Our ref: SO/2023/123043/01-L01
Your ref: EN070007 – Deadline 1
Date: 17 April 2023

APPLICATION BY LIVERPOOL BAY CCS LIMITED FOR AN ORDER GRANTING DEVELOPMENT CONSENT FOR THE HYNET CARBON DIOXIDE PIPELINE SCHEME

ENVIRONMENT AGENCY DEADLINE 1 (17TH APRIL 2023) SUBMISSION:

DRAWING TITLE  
**Ince - Above Ground Installation (AGI) Drainage Layout**

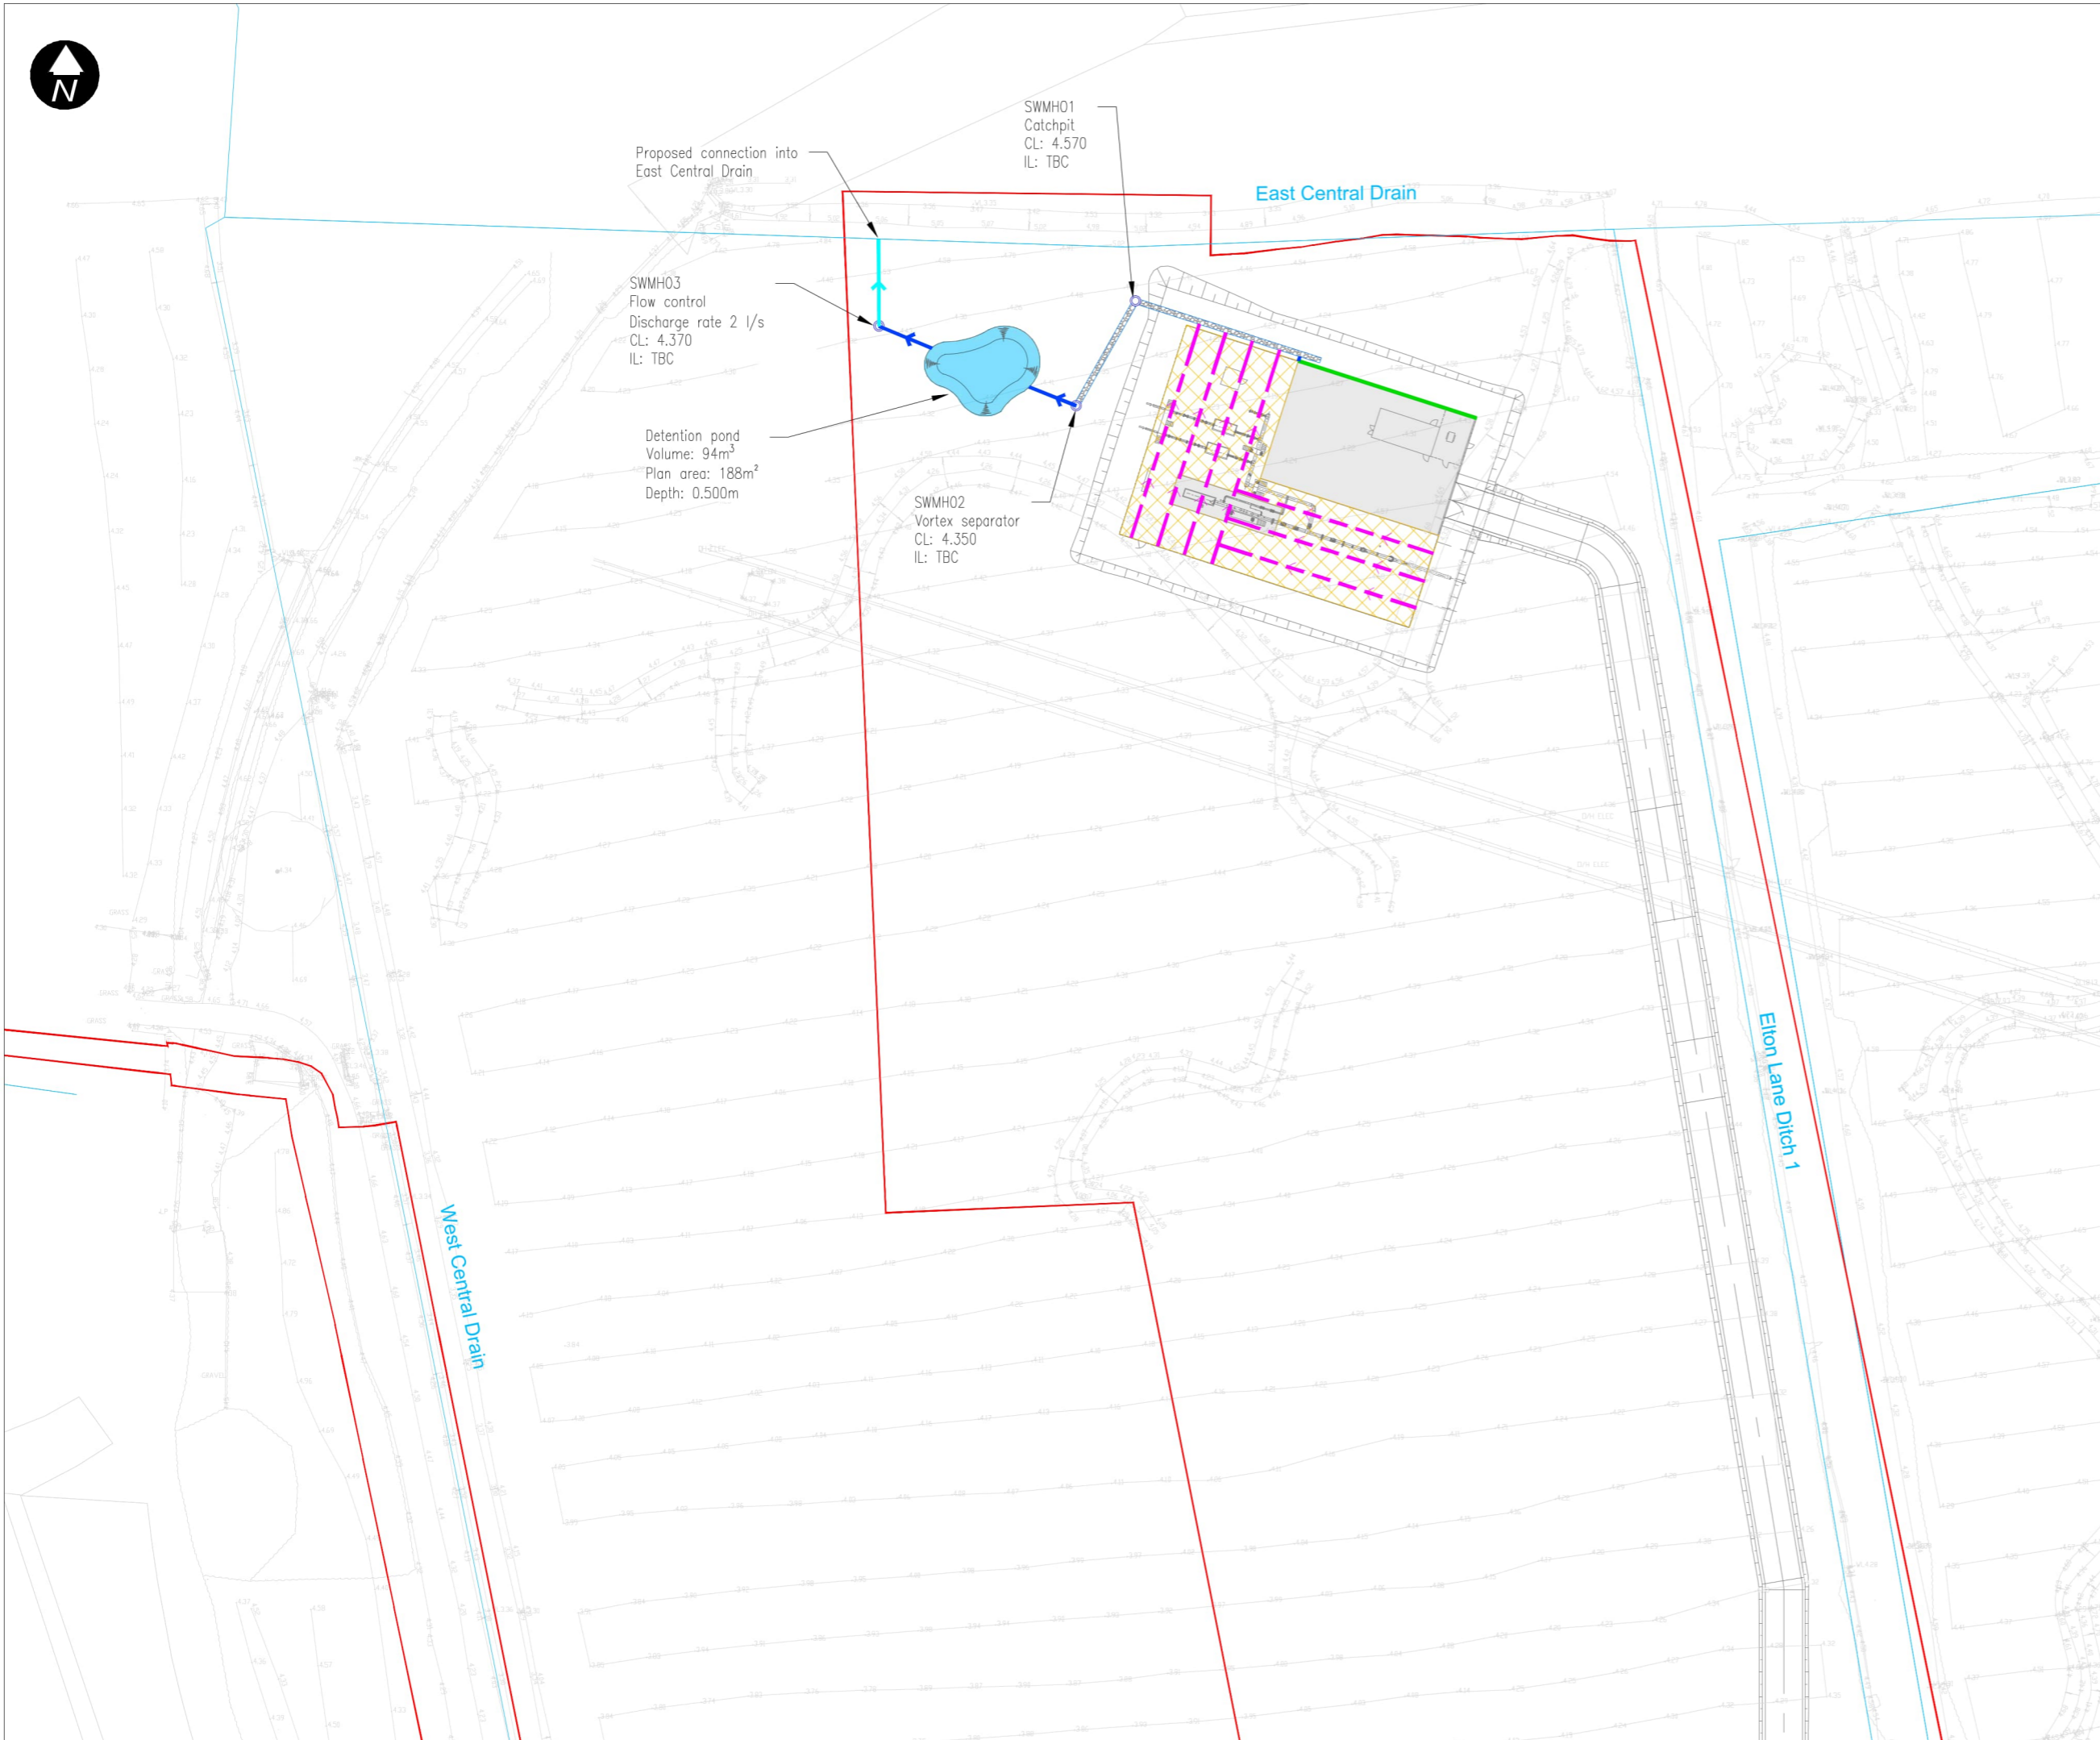
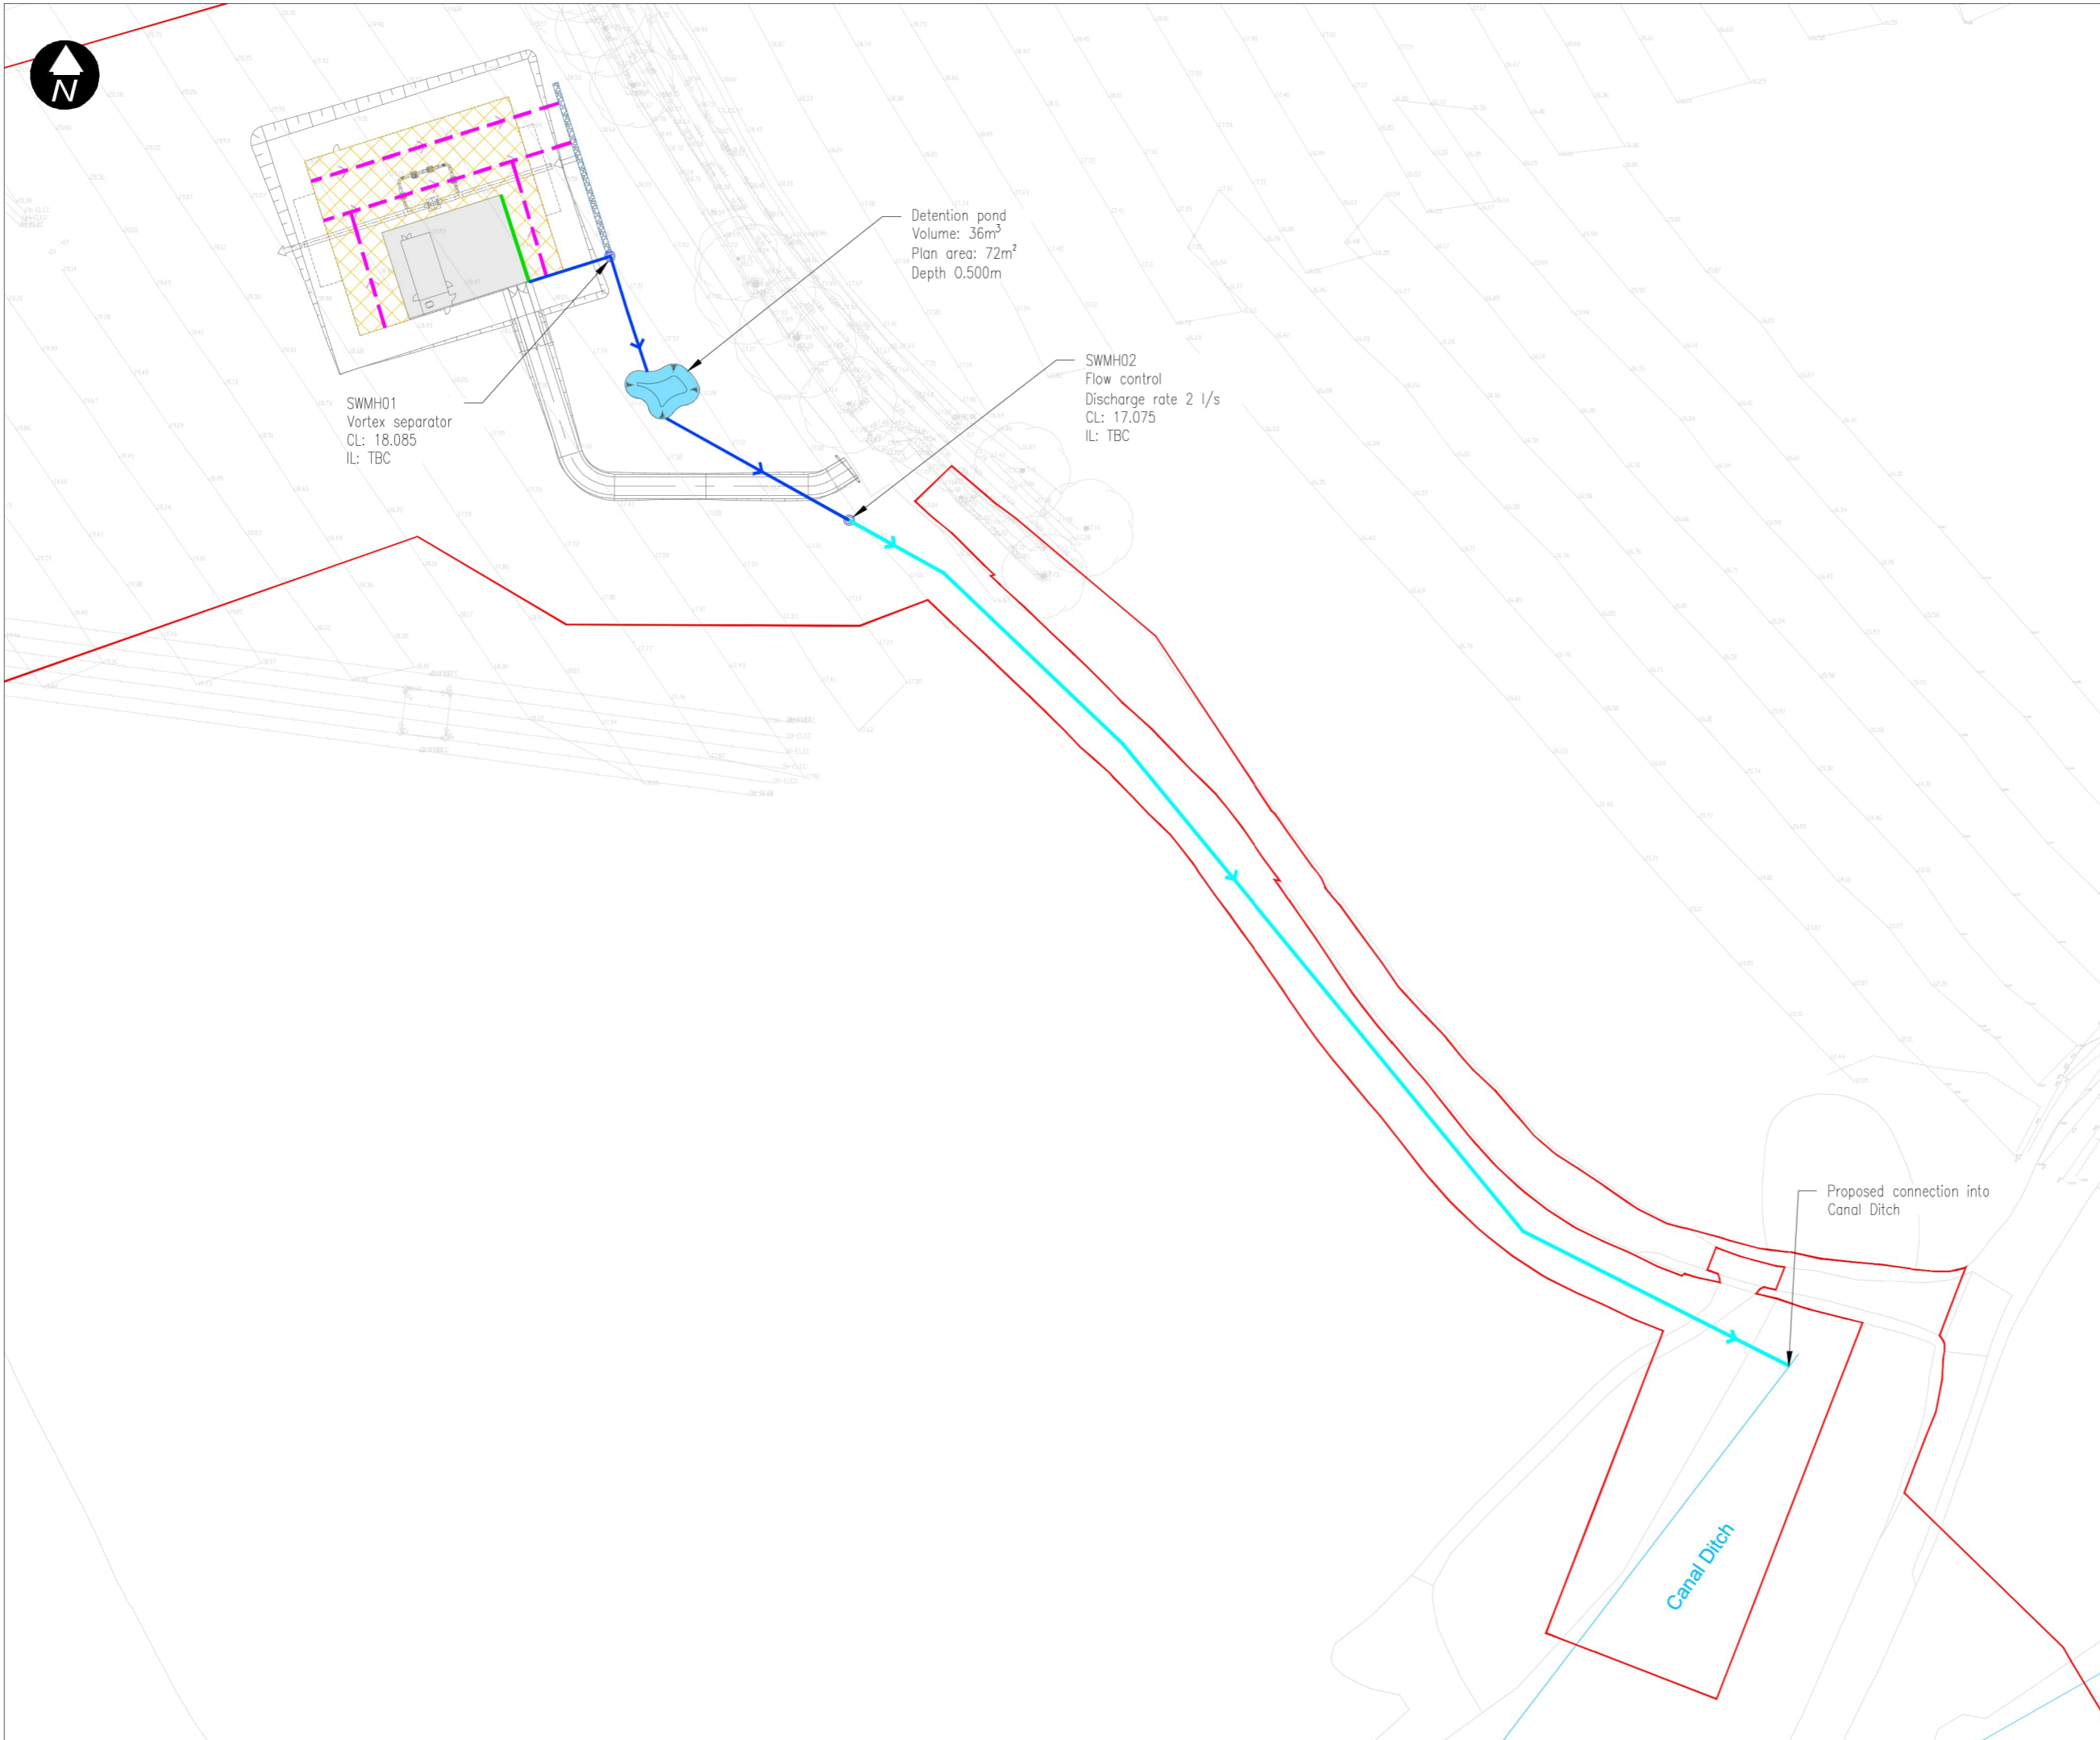
- It is unclear at this time whether the proposed scheme may impact sites with existing Environmental Permits regulated by the EA. We note there is an intention for the surface water drainage proposals for the Stanlow Above Ground Infrastructure (AGI) to connect to the wider Essar Stanlow Refinery effluent network and advise further information is required to determine whether such proposals are feasible.
